Drainage engineer comments;

NOTIFICATION FROM ARUN DISTRICT COUNCIL
Town & Country Planning Act 1990 (as amended)
Town and Country Planning (Development Management Procedure) (England) Order 2015
Planning Permission
APPLICATION Y/22/17/PL
NO:

Registered: 27th March
2017
Site Address: Land rear of 2,4 & 6 Gladstone Road Mill View Road Yapton
BN18 0JP
Grid Reference: 497763 102677

Description of Works: 1 No. dwelling

Site Plan

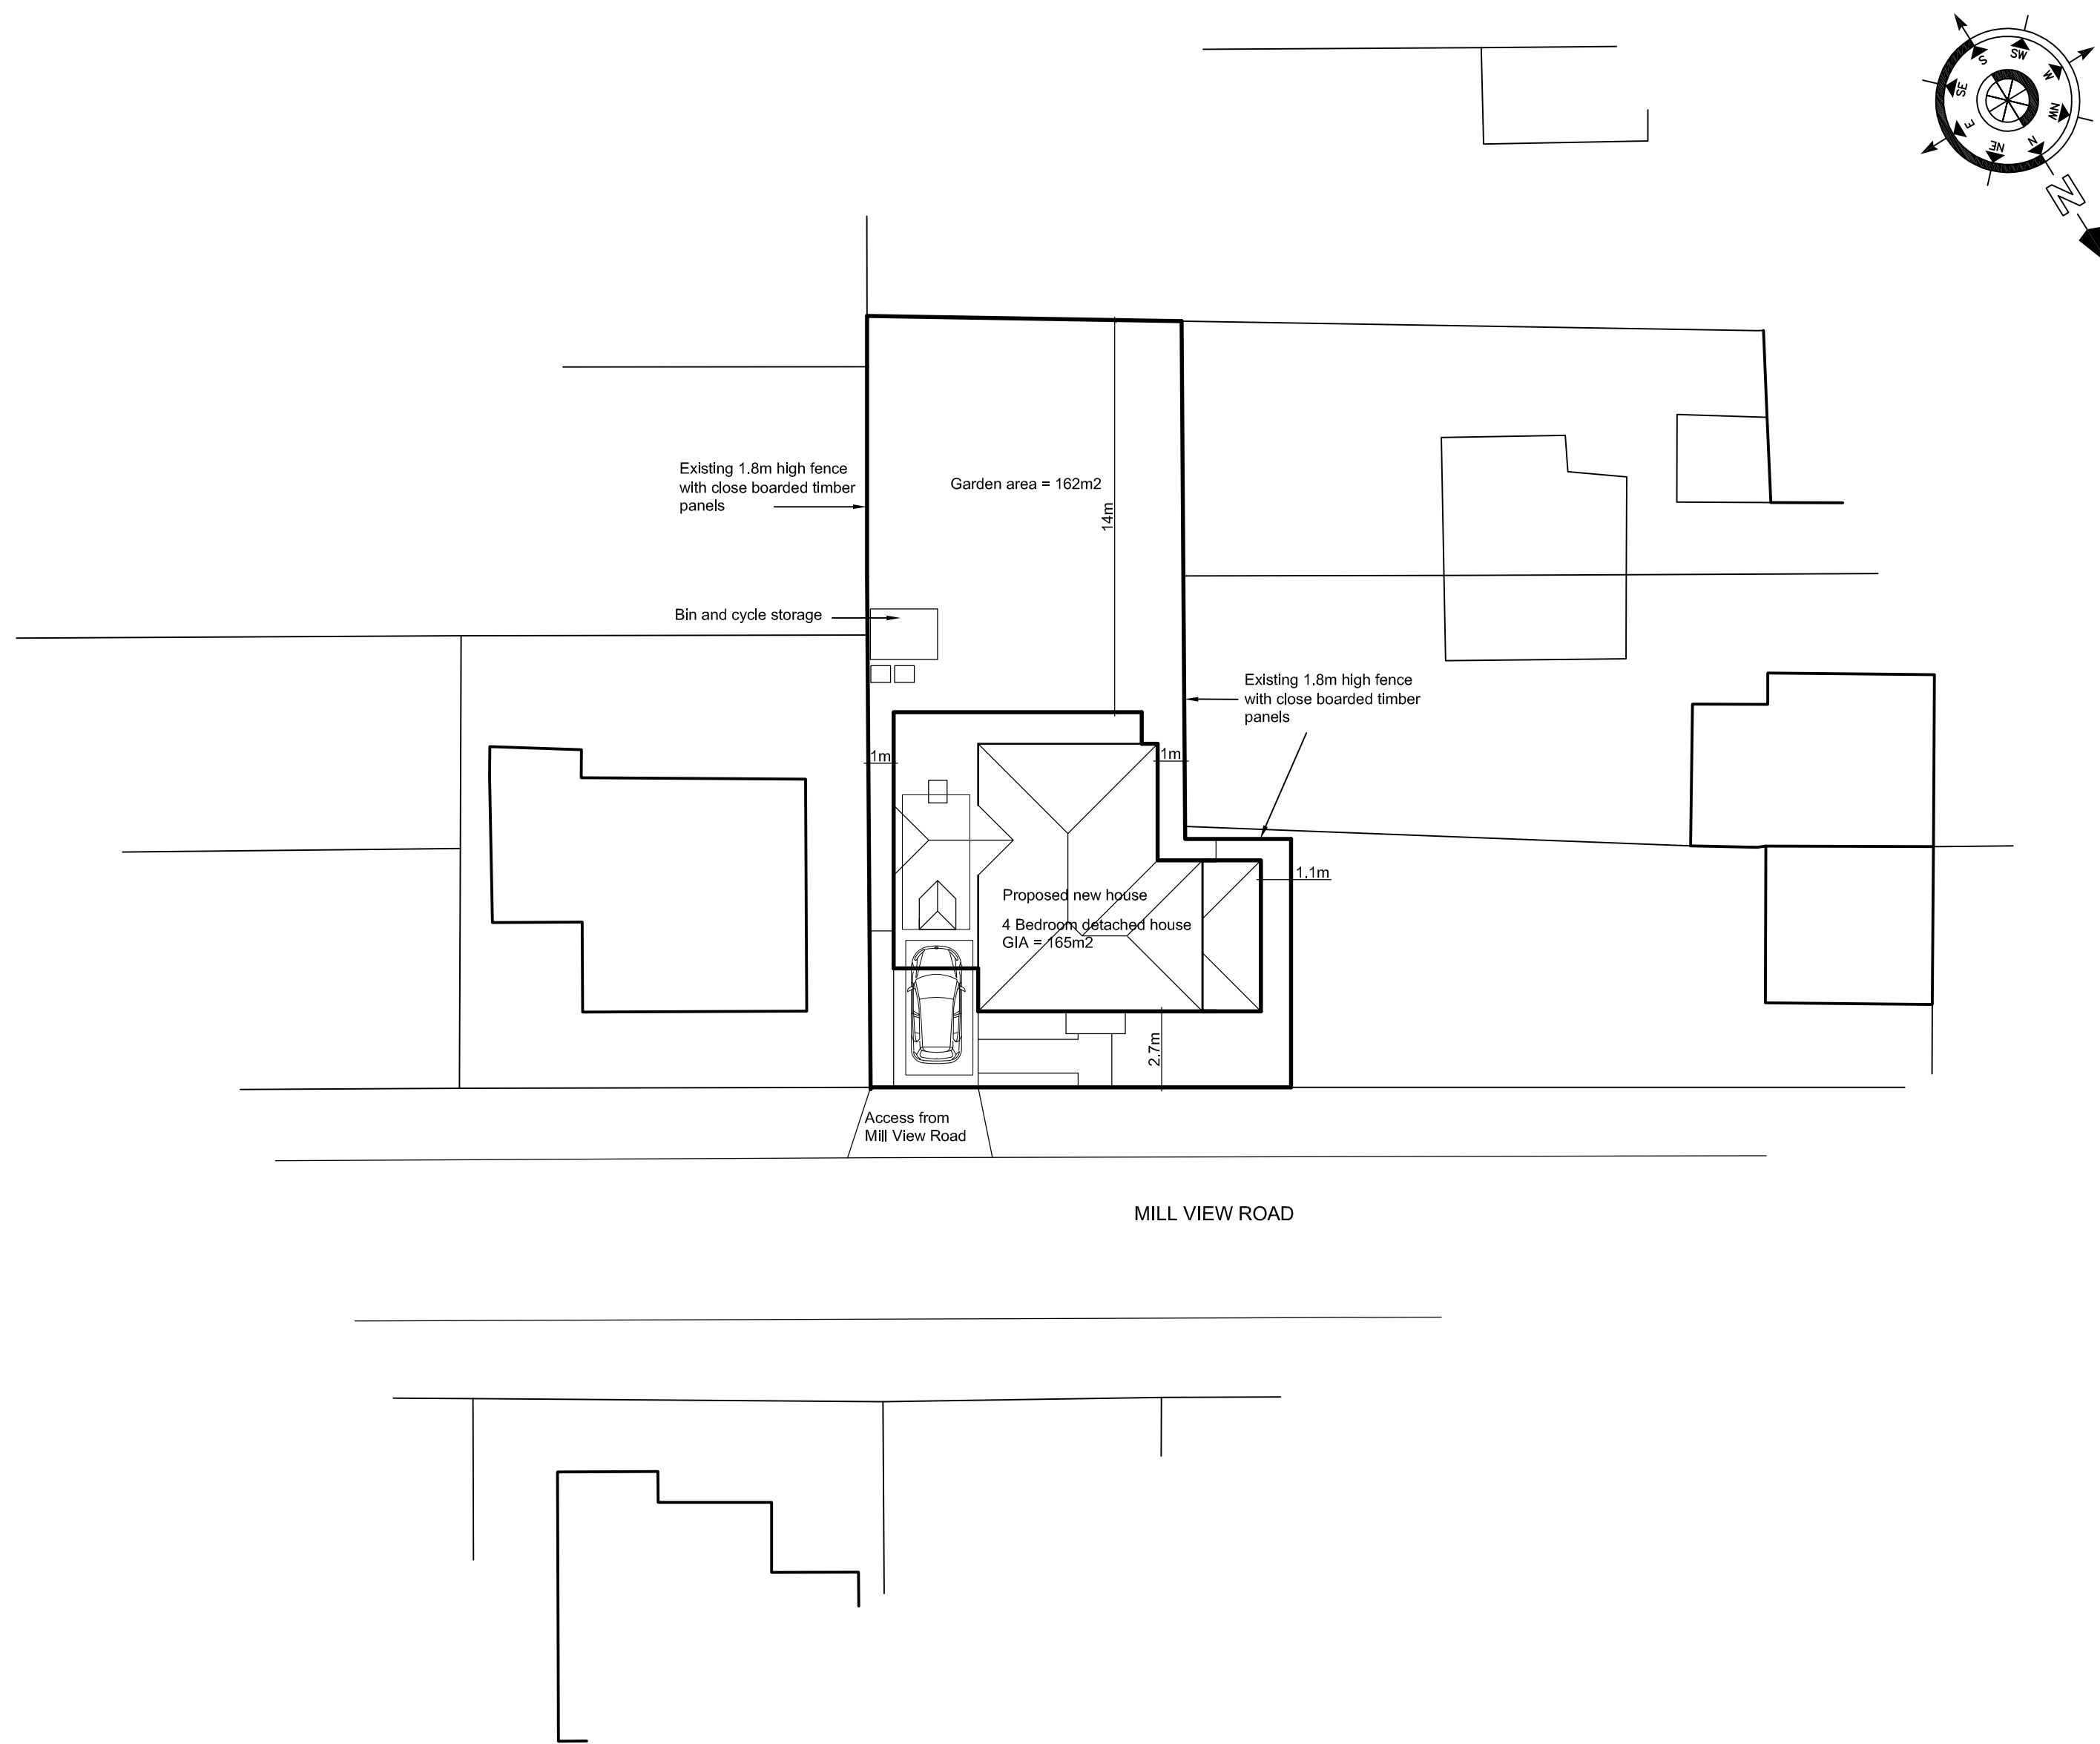
Please also note that we believe there is a highway drain located within the pavement adjacent to the proposed development. This may be affected by the proposed crossover, so WSCC comments should be sought in this respect.
